Lady Ann Road, Batley, Kirklees

Road Safety Audit Stage 1

Lady Ann Road, Batley, Kirklees – Road Safety Audit Stage 1

2023-12 Batley RSA1 – Revision 0

DRAWING  
 1247 PL 504 rev A

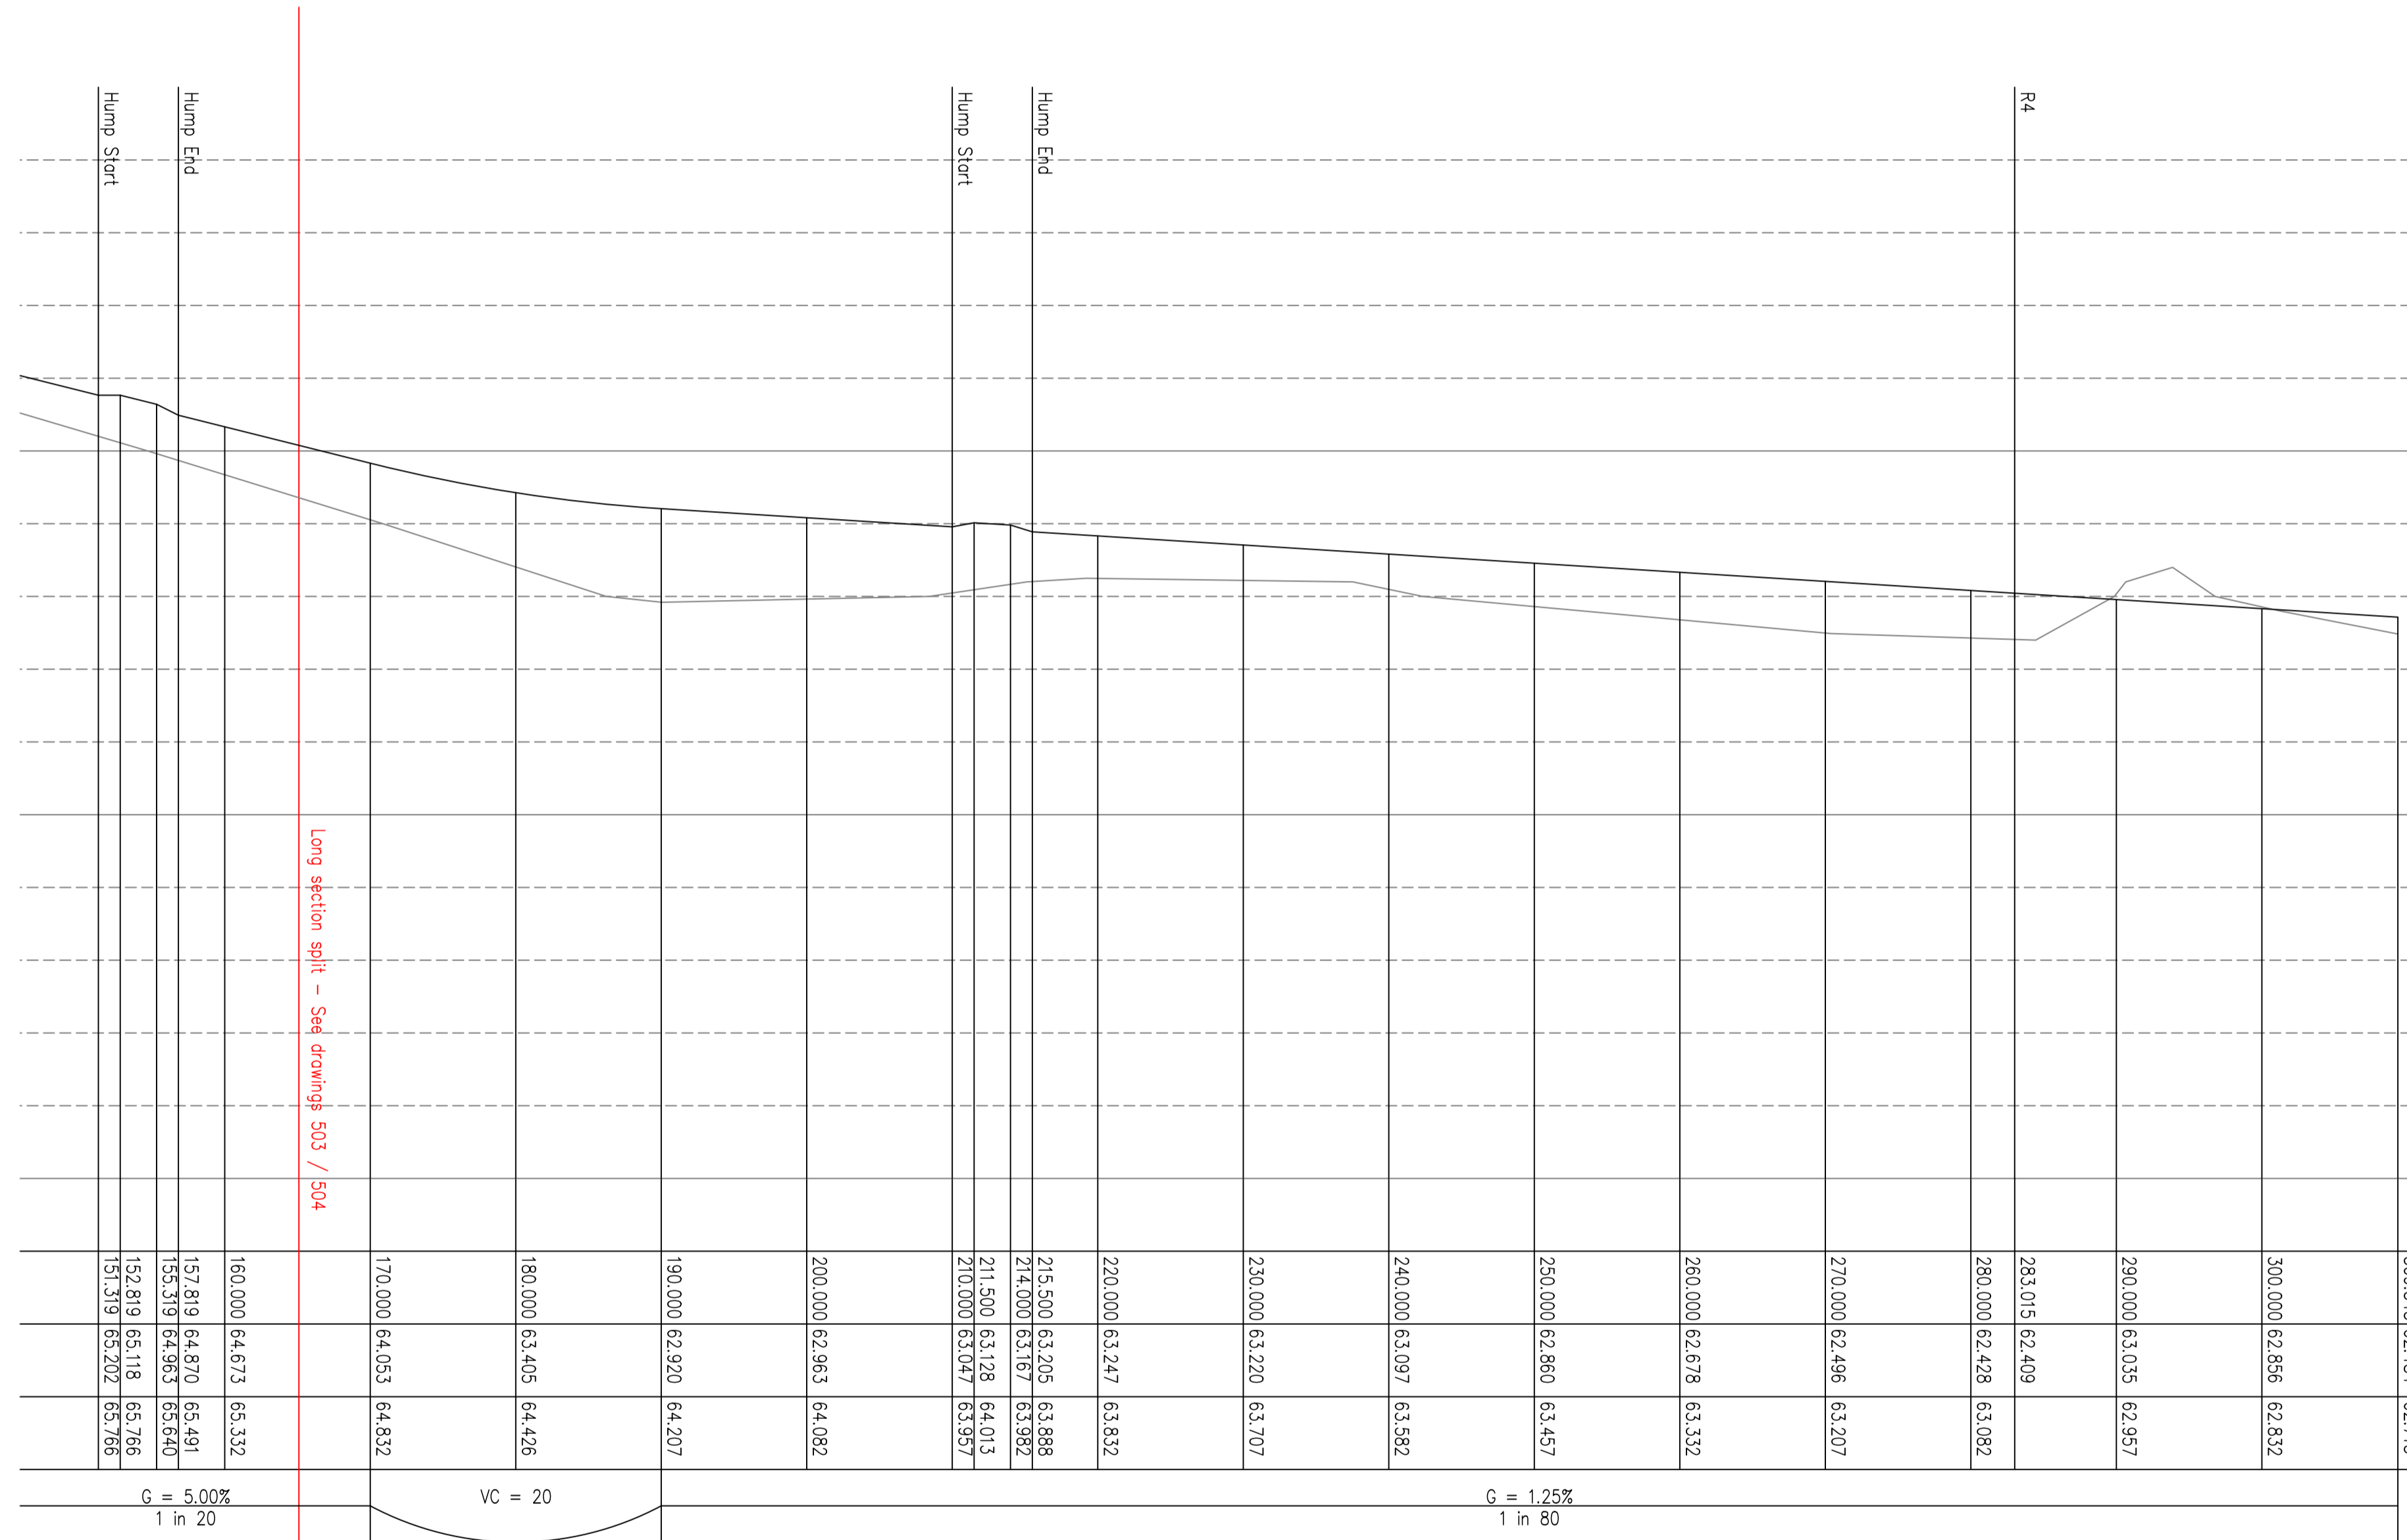
Location: Internal development roads – Road 1 and Road 3

Summary: Skidding Resistance – Insufficient skidding resistance may increase the risk of loss of control type collisions.

No details have been provided of the polished stone values (PSV) of the bituminous materials, especially with consideration of the proposed estate road gradient on Roads 1 and 3, which have a maximum gradient of 6.66%. In addition, there are likely to be inspection chamber covers on gradients and near junctions. Insufficient carriageway construction with low PSV values or covers with a low PSV may increase the risk of overshoot, rear shunt or collisions involving pedestrians and may also increase the risk of skid/loss of control type collisions for powered two-wheel users.

Location: Internal development roads – Road 3

Summary: Pedestrians – Insufficient provision may increase the risk of collisions involving pedestrians and other active modes.

Footway provision ends on Road 3 around Chainage 80m, forming a shared use road to the northern extremity that will be 230m long. Noting the provision of vertical traffic calming, the audit team consider that this would be too long a distance for a shared use road, in particular with the lack of any bends, junctions or buildouts. Insufficient provision may increase the risk of collisions involving pedestrians and other active modes.

It is recommended that a minimum 55 PSV is provided where gradients exceed 5% and that inspection chamber covers provide a similar level of skidding resistance to the surrounding carriageway surface.

It is recommended that a footway is provided along at least one side of Road 3 for the majority of the road length.

Drawing no: 10703-SELF-P-ZZ-A-M3-301  
 Rev: A

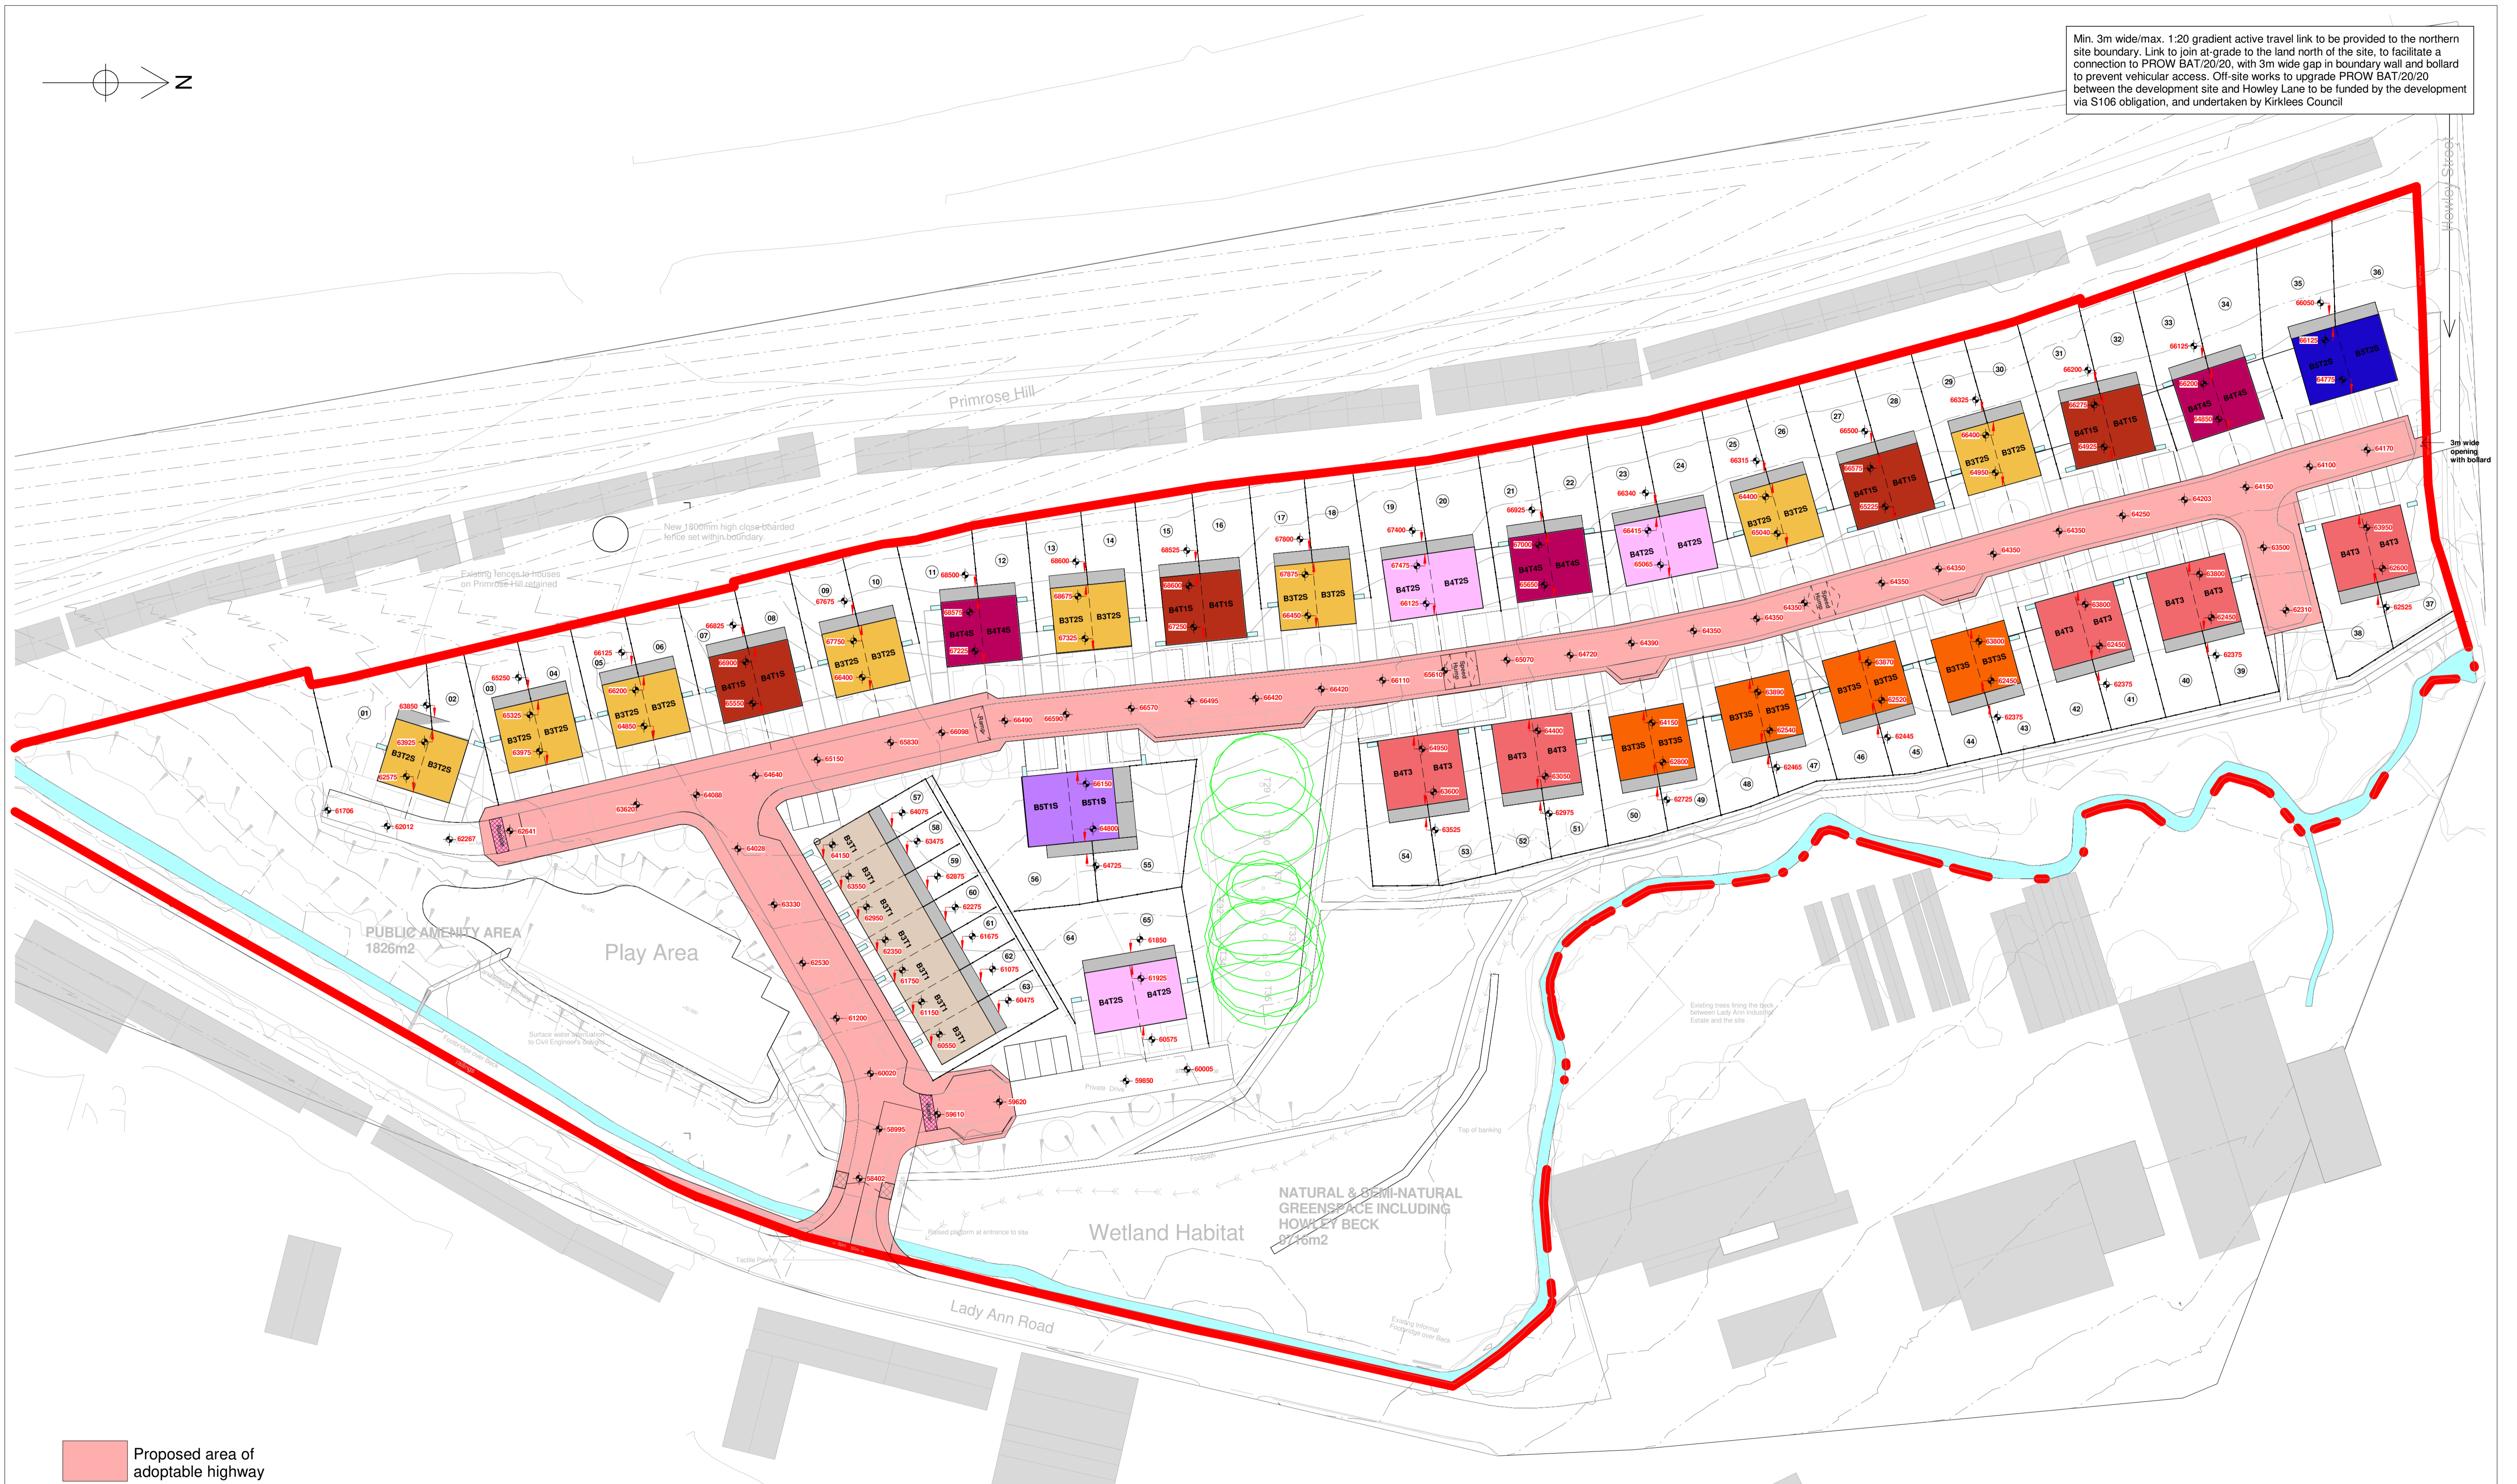
Location: Junctions and bends on the internal development roads

Summary: Visibility – Insufficient forward visibility into side roads and around bends may increase the risk of collisions involving pedestrians.

Forward visibility appears to have been checked on one of the internal road bends, but not the left turns between development roads where parking provision may obstruct forward visibility for left turning vehicles in particular. Insufficient forward visibility around bends or into turning heads may increase the risk of collisions involving pedestrians, especially in roads where children may be playing.

Location: Main access and internal development roads

Summary: Drainage – Insufficient surface water drainage may increase the risk of skidding type collisions at the junction as well as slips and falls by pedestrians

At this early stage, no details have been provided on the proposed drainage arrangements. It was noted that the development site graded significantly down towards Lady Ann Road. As such, this may require measures to manage surface water towards at the junction with Lady Ann Road to reduce the risk of standing water and detritus in the turning heads that may consequently cause skidding type collisions in this area. Also, the Road 3, appears to grade down at each end. Without suitable provision for surface water, these areas may become prone to standing surface water, detritus and icy patches that may increase the risk of slips and falls which can be life changing for older pedestrians.

Location: Existing Watercourse and Wetland Areas

Summary: Fences and Road Restraint Systems – Lack of barrier protection to the existing beck may increase the risk that pedestrians or other road users enter the beck or wetland areas and sustain injuries or drown.

A beck is indicated passing under the proposed development access, along with an area of wetland, it is however unclear from the highway drawings if any barrier or fence will be provided in the proposed state. Regardless of the depth of water or level difference between the water and surrounding embankment tops, there is a risk that pedestrians or other road users may fall into the beck or wetland area sustaining injuries, with an additional consequential risk of drowning. There is also a risk that an errant vehicle may enter the beck or wetland areas. As such, an evaluation of this risk should be undertaken to establish what type of road restraint system is required on this interface. A lack of appropriate barrier protection may increase the risk that pedestrians or other users enter the beck or wetland areas and sustain injuries or drown.

Location: Internal development roads

Summary: Specific Road Users – Lack of dropped crossings on desire lines may increase the risk of collisions involving users with mobility issues.

There may be desire lines for pedestrians between footways which have no provision for pedestrians with mobility issues, specifically those users with prams, wheelchairs or mobility scooters. The alternatives for these users may require them to use drop kerbs provided for driveways or to cross at locations where visibility to approaching vehicles may be otherwise compromised. This lack of dropped crossing on a desire line may increase the risk of collisions involving users with mobility issues.

Location: Proposed Development Roads and pedestrian links to adjacent roads.

Summary: Lighting – Lack of or insufficient carriageway lighting may increase the risk of collisions, trips and falls during the hours of darkness.

It is unclear from the information provided if any carriageway lighting is to be provided either on the development road or on the footways linking the development to other adjacent roads. A lack of carriageway lighting, footway lighting or insufficient levels of illumination may increase the risk of collisions between vehicles and active mode users as well as trips and falls by pedestrians during the hours of darkness.

It is recommended that forward visibility around the inside of bends and in particular into left turns is assessed and that the visibility envelope is kept clear of obstructions such as planting, fencing, walls, areas for parking etc, in line with Manual for Streets. i.e. planting when mature should not exceed 600mm from the adjoining carriageway surface with the underside of any tree canopy to be above 2000mm.

It is recommended that drainage details are provided at the next stage of road safety audit including gully locations, levels and contours.

It is recommended that a barrier treatment proportionate to the level of risk is provided between the beck/wetland areas and areas where pedestrians and other road users may use.

It is also recommended that any parapet arrangement over the beck is located to the back of the junction visibility envelope of the development access onto Lady Ann Road.

It is recommended that a dropped pedestrian crossing with (ideally) tactile paving should be provided at these locations. Specific locations will need to consider the risk of vehicle overrun damage to the tactile paving by large vehicles, in particular refuse collection vehicles.

- Across Road 1 – Across junction mouth
- Across Road 1 – Around Chainage 30m
- Across Road 1 – Around Chainage 70m
- Across Road 2 – Across junction mouth
- Across Road 3 – Around Chainage 25m
- Across Road 3 – Around Chainage 45m

It is recommended that carriageway lighting is provided on both the development roads and all footway links.

It is also recommended that any carriageway lighting provided within the development is located such that columns are clear of being a hazard for manoeuvring vehicles. i.e. not placed between adjacent parking spaces.
